From: Jonathan Emanuel
Sent: 05 April 2024 08:16
To: Katherine Daniels
Cc: DC.Consults
Subject: RE: Planning notification for application reference: 24/00725/DISC

Having reviewed the submitted AMS by Asset Max, the AMS does not provide sufficient details to discharge the condition. The drawings within the AMS do not provide detail for the tree protection, providing details and positioning.

Drawing No. A-030-COND 6&11 & 13&14 and 5 Date MARCH 2023

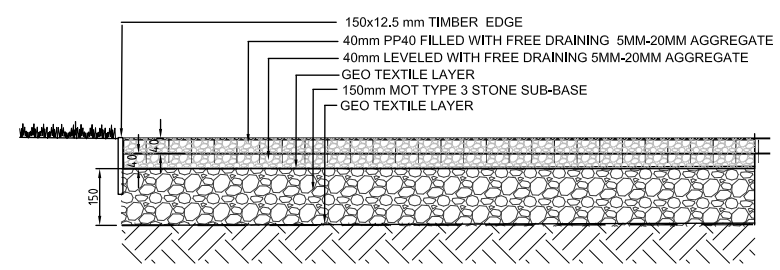
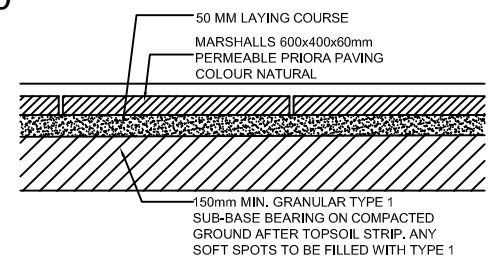
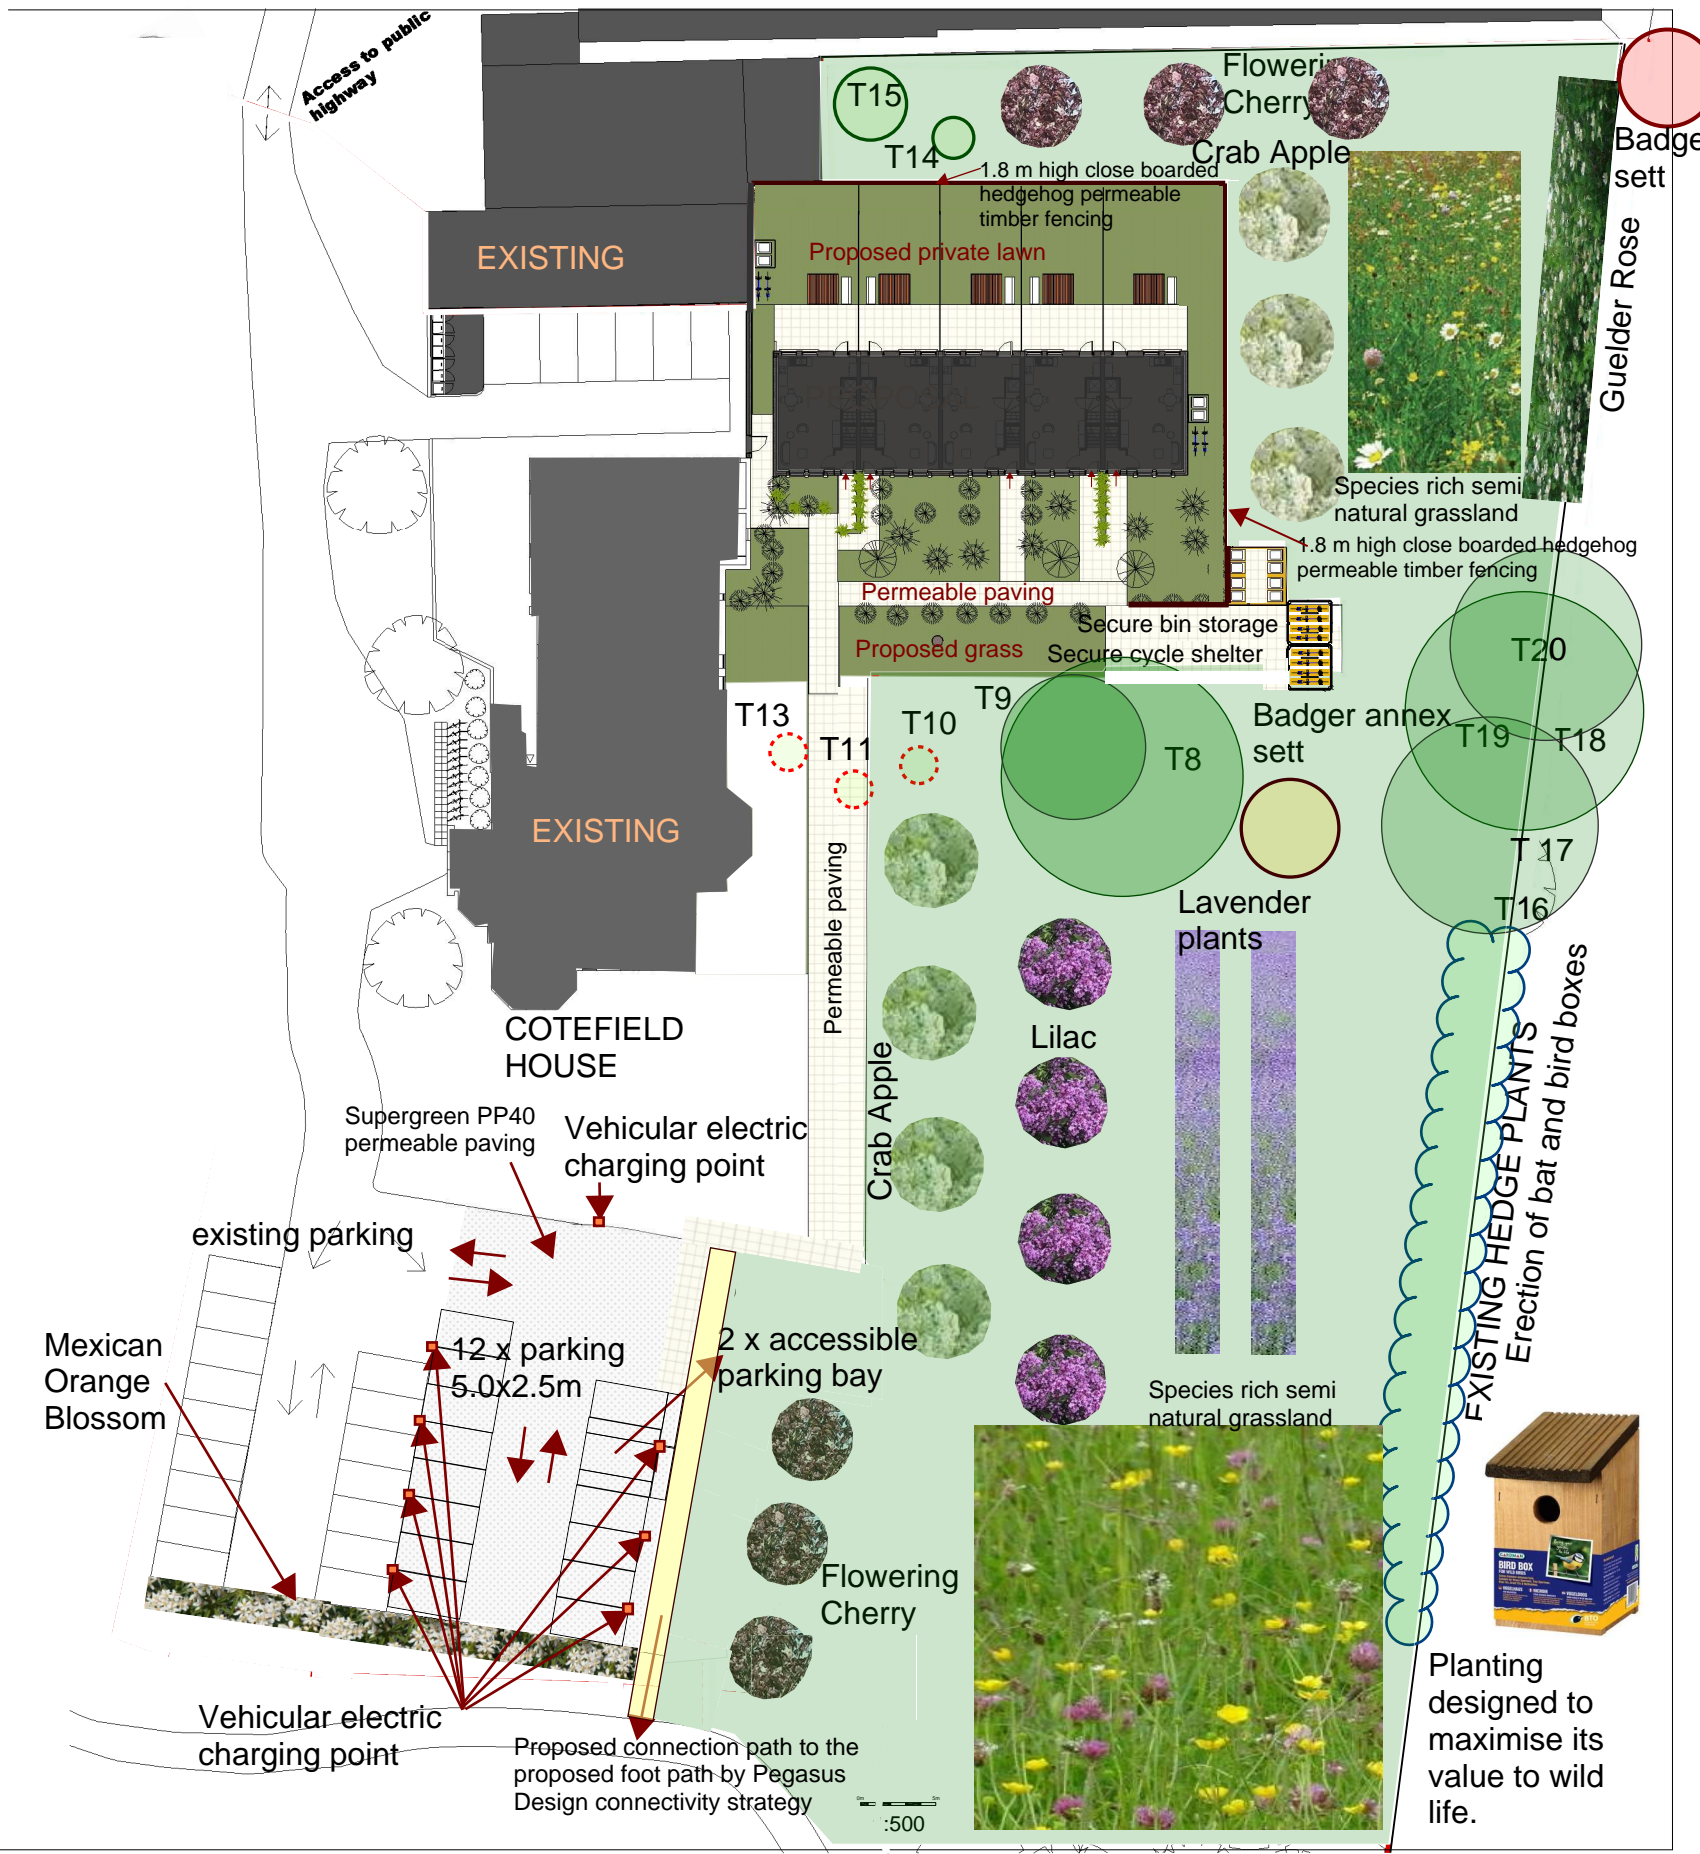
The report states Once the site protection fencing is installed than the main development can start, this should then be identified on a plan to show where the protection fence needs to be positioned.
